CITY OF PORTLAND, MAINE
 DEVELOPMENT REVIEW APPLICATION
 PLANNING DEPARTMENT PROCESSING FORM

2010-0014
 Application I. D. Number

55 Demerest Street
 Project Name/Description

From: Michael Farmer
To: Machado, Ann
Date: 12/30/2010 8:53 AM
Subject: 55 Demerest Street single unit residential site plan

DATE: November 04, 2010
SCALE: AS NOTED
DRAWN
PLC
SHEET: 1 of 1

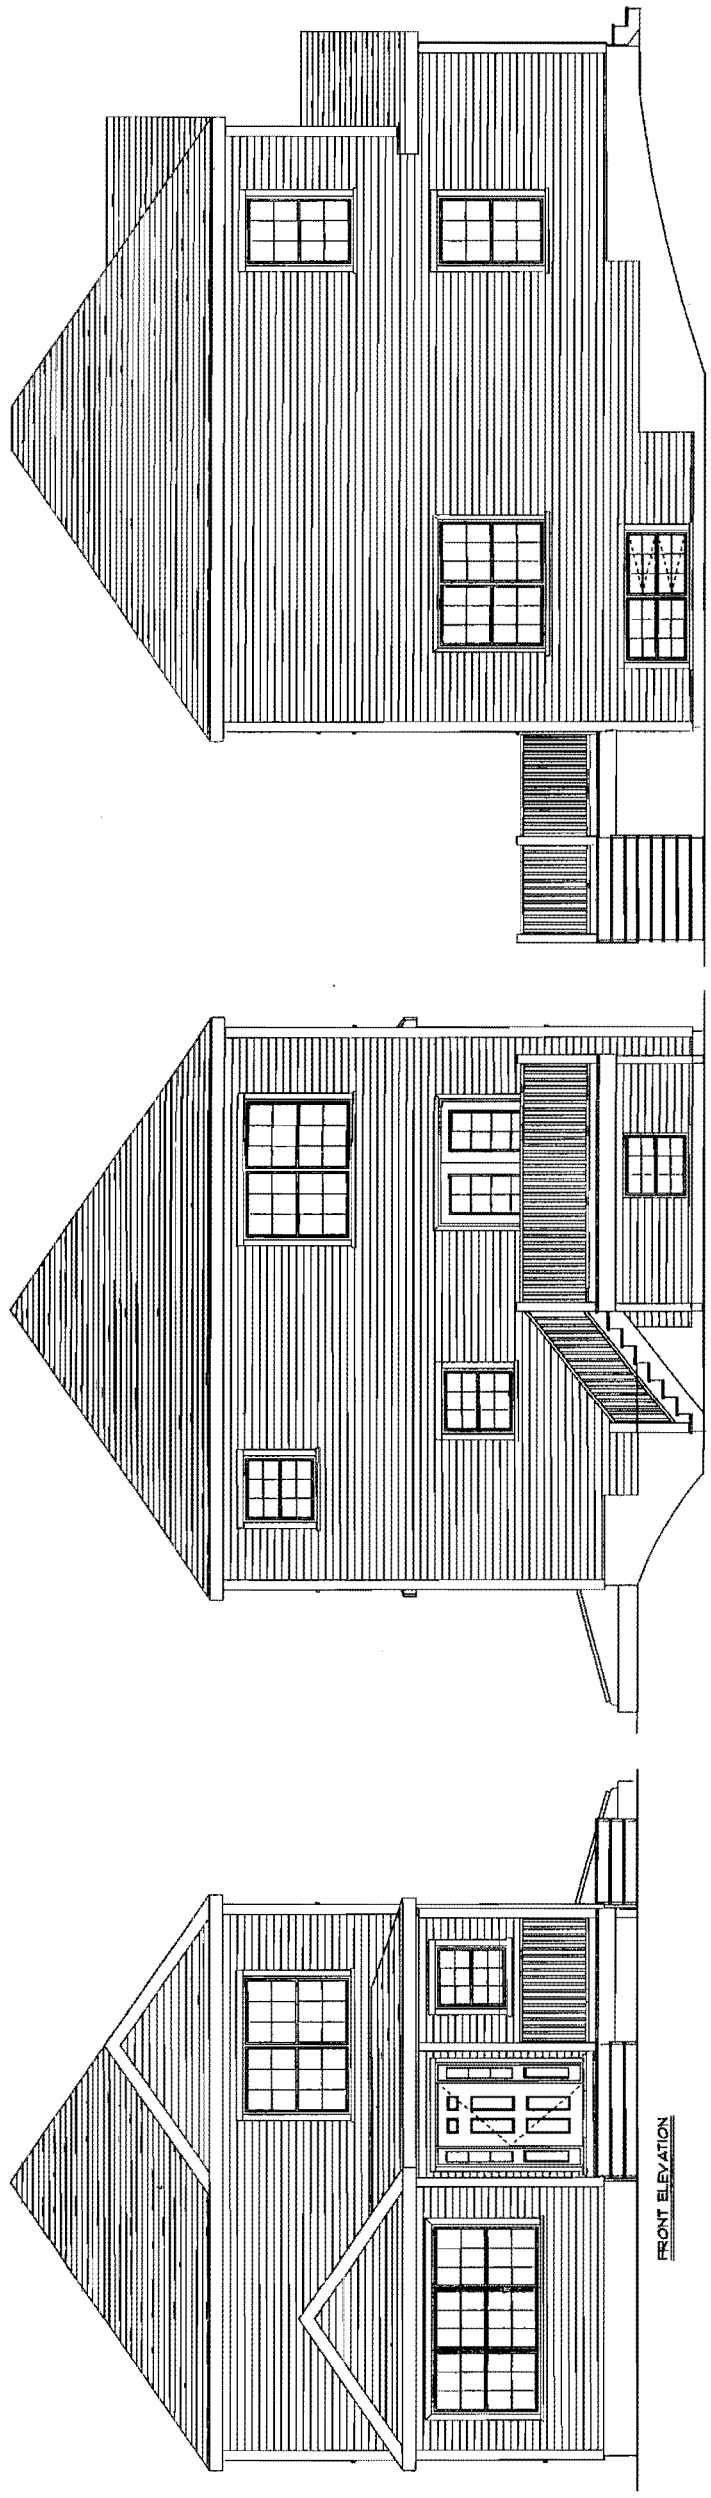
- The deck on the site plan needs to be changed to 8' x 12'.
- The driveway needs to be bumped out another foot at the bulkhead so the parking space is 9' wide.
